Recommendation Report for Planning Permission for Works or Extension to a Dwelling

REF NO: EP/107/25/HH

LOCATION: 34 Angmering Lane  
East Preston  
BN16 2TA

PROPOSAL: Existing front porch to be replaced with a new single-storey extension, new external windows and doors throughout, new external cladding and render to walls, and new dormers to the East and West elevations. A new air source heat pump on the North Elevation/boundary.

Rev.	Notes	Date
 NAT DESIGN ARCHITECTURAL SERVICES M: 07599199759 E: info@nat-design.co.uk www.nat-design.co.uk		
Project		
Rangers, 34 Angmering Lane, East Preston, BN16 2TA		
Drawing		
Proposed Floor Plans		
Drawn By	Scale	
NSE	as shown	
Date	Revision	
Nov 2025		
Drawing No.		
1494 - DPA - 04

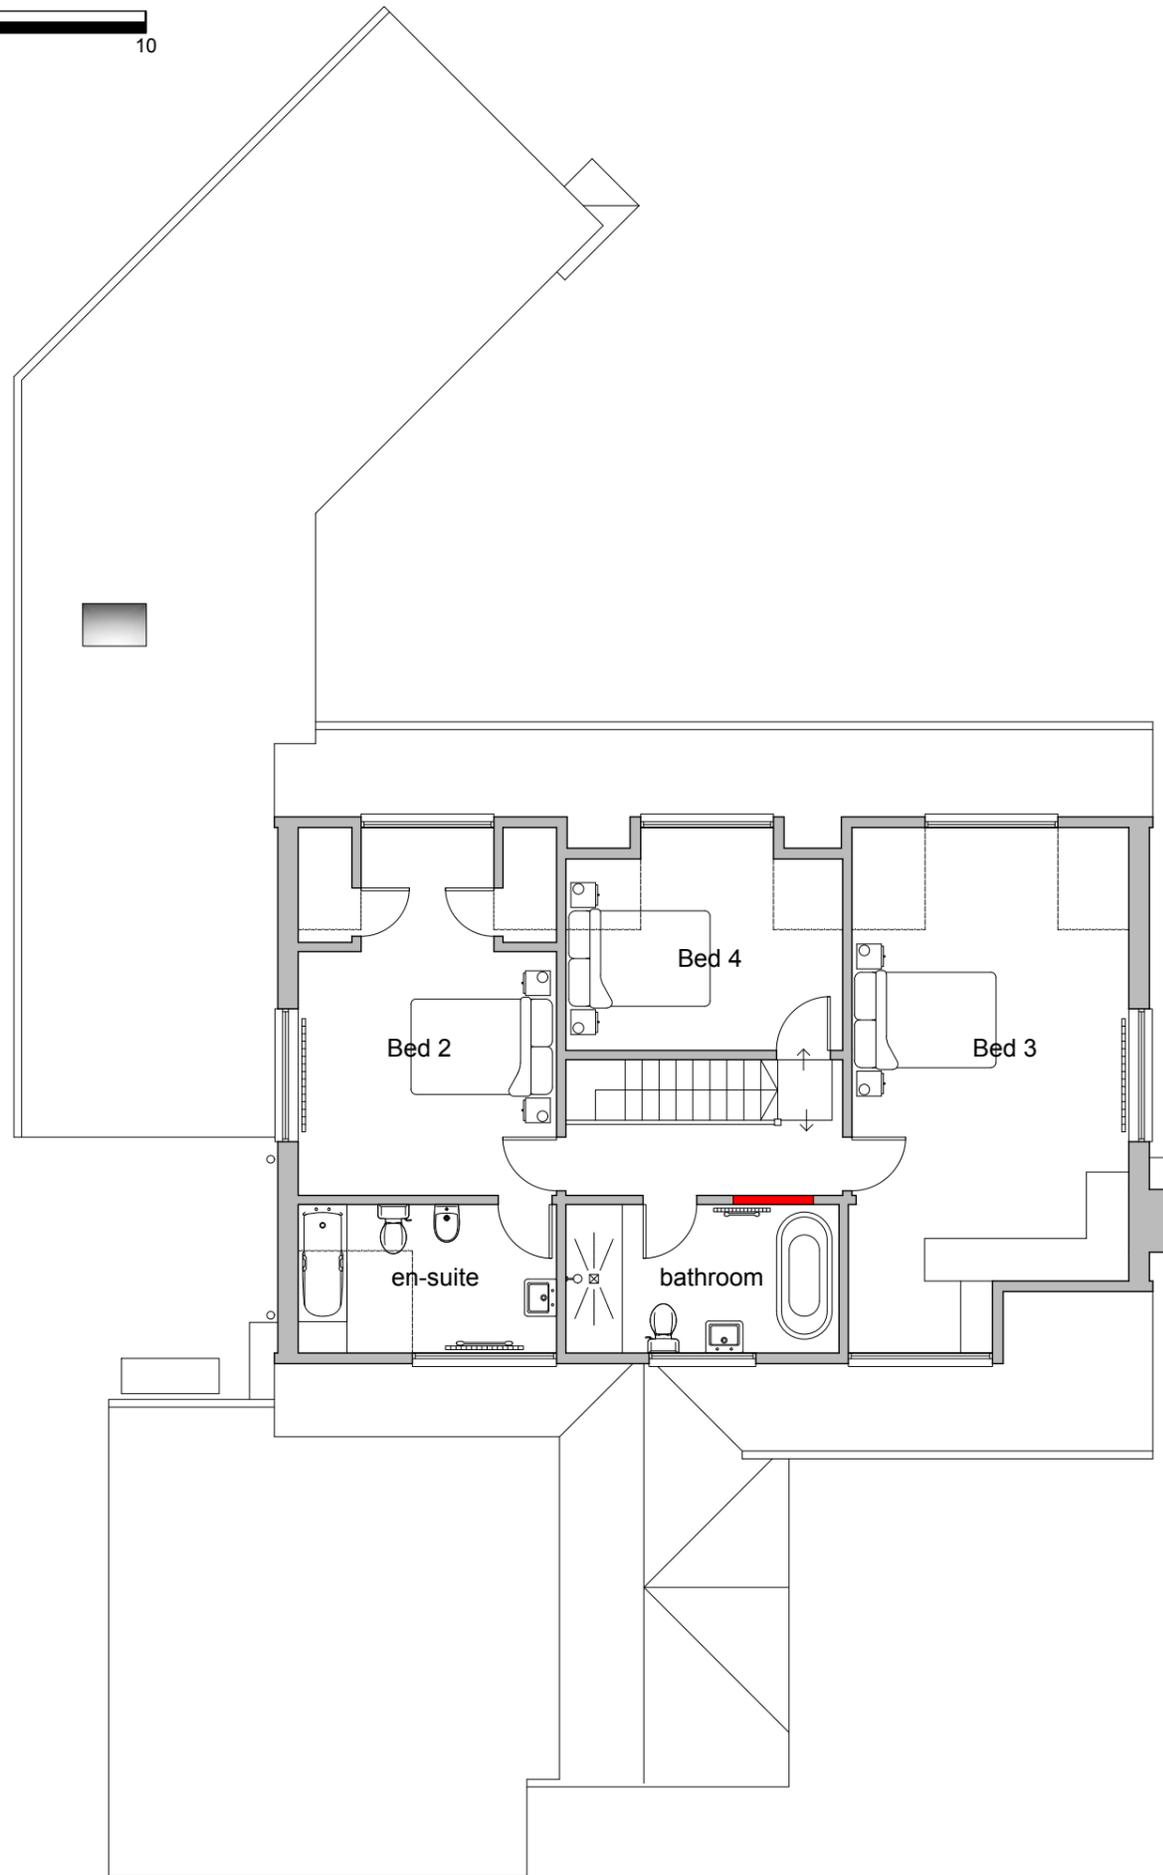
The proposed front single storey (sunroom) extension would replace an existing porch and increase the width by approximately 0.1m to 3.8m and increase the depth by approximately 0.05m to 4.8m. The existing porch is incorporated within the host dwelling and the proposed front single storey extension would alter the visual appearance from a flat roof to an intersecting hip to hip roof with a maximum height of 3.7m.

The proposed front single storey (sunroom) extension would exceed the Arun Design Guide (ADG) depth of 1.5m, however, it would replace an existing porch of a similar footprint and therefore, would not disrupt the building line or street scene and would be in accordance with Part M of the ADG.

Fenestration to the front elevation would replace an existing double casement glazed door and large single window with a new double casement glazed door flanked by two separate thin vertical windows and would be a slight realignment of the entrance to the host dwelling. The fenestration would be finished in white and be wooden faced with aluminium on the outside. The proposal would be finished with millboard cladding and cement render, painted in the base colour of the millboard cladding (taupe/stone/beige) and tiles to match the existing host dwelling.

The proposed ASHP would be located to the side (north) boundary of the host dwelling, sited behind the garage (east flank) and would be set in 3m from the side (north) boundary. Environmental Health have been consulted as part of this application and have raised no objection to the ASHP subject to a condition requiring an acoustic impact assessment to be submitted and approved in writing by the Local Planning Authority. As such, subject to the required condition, the development would not result in unacceptable noise impacts and would be in accordance with Arun Local Plan policy QE DM1.

Drawn by NSE	Scale as shown	Drawing:  Proposed Roof Plan	Project: Rangers, 34 Angmering Lane, East Preston, West Sussex BN16 2TA
Date Nov 2025	Revision		
Drawing 1494 - DPA - 10

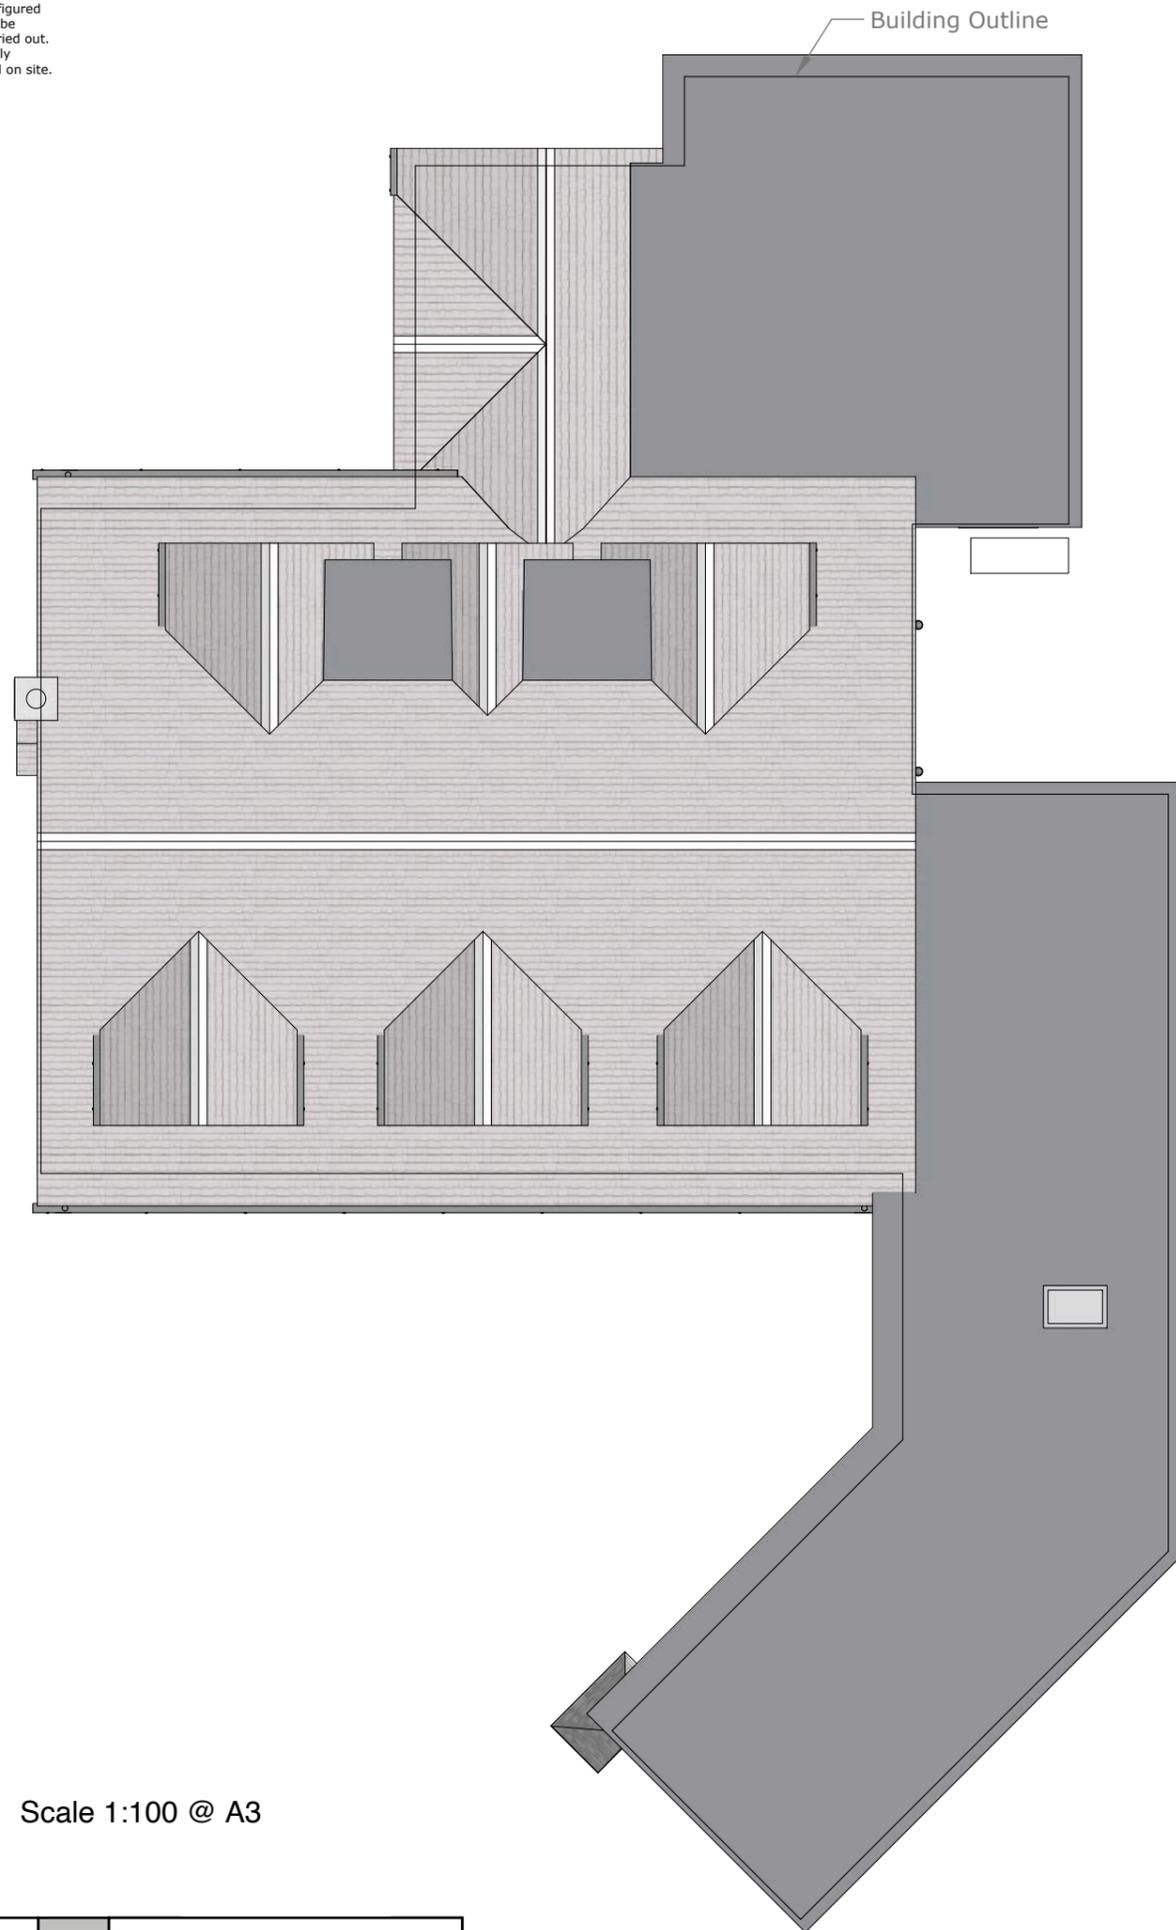
The proposal seeks to alter the dormers within the east and west roof slopes from flat roofs to pitched roofs which would be sympathetic to the original form of the roof and reflect the character of the area.

The western elevation comprises of a single flat roofed dormer that would be designed to form three individual gable end pitched dormers connected by a flat roof dormer between. The proposal would increase the total width of the dormer by 0.5m to approximately 9.3m. The central dormer is of a smaller size with an increase in approximate height of 0.6m to 2.2m and a reduction in eaves height of approximately 0.5m to 0.8m to account for the change in roof pitch. The dormers either side would increase in approximate height of 0.9m to 2.5m high and a reduction in eaves height of approximately 0.5m to 0.8m to account for the change in roof pitch.

The proposed central dormer would have an increased depth of approximately 0.7m to 2.4m and the dormers either side would have an increased depth of approximately 1m to 2.7m ensuring a uniformed depth appearance. The central dormer would be set lower into the roof slope at approximately 1.8m from the roof ridge and the dormers either side would be set into the roof slope approximately 1.5m from the roof ridge. The proposed alterations to the dormers would reflect the character of the host dwelling and would not result in harm to the visual amenity of the host dwelling or street scene.

The eastern elevation comprises of three separate dormer units that increase the total width of the three dormers by 0.6m to approximately 11m. Each dormer would increase in depth by approximately 1m to 2.7m and width by approximately 0.6m to 3m. Each dormer would increase in height by approximately 1.2m to 2.8m and a reduction in eaves height of approximately 0.3m to 1m to account for the change in roof pitch. The separation distances between the dormers would reduce by approximately 0.2m to 1.3m but maintain their equal separation distances. The dormers would be set into the roof slope higher by 0.9m at approximately 1.3m from the roof ridge. The proposed alterations to the dormers would remain subservient to the eastern roof slope of the dwelling and would reflect the character and appearance of the host dwelling. As such, the proposed alterations to the dormers would not result in harm to the visual amenity of the host dwelling or street scene.
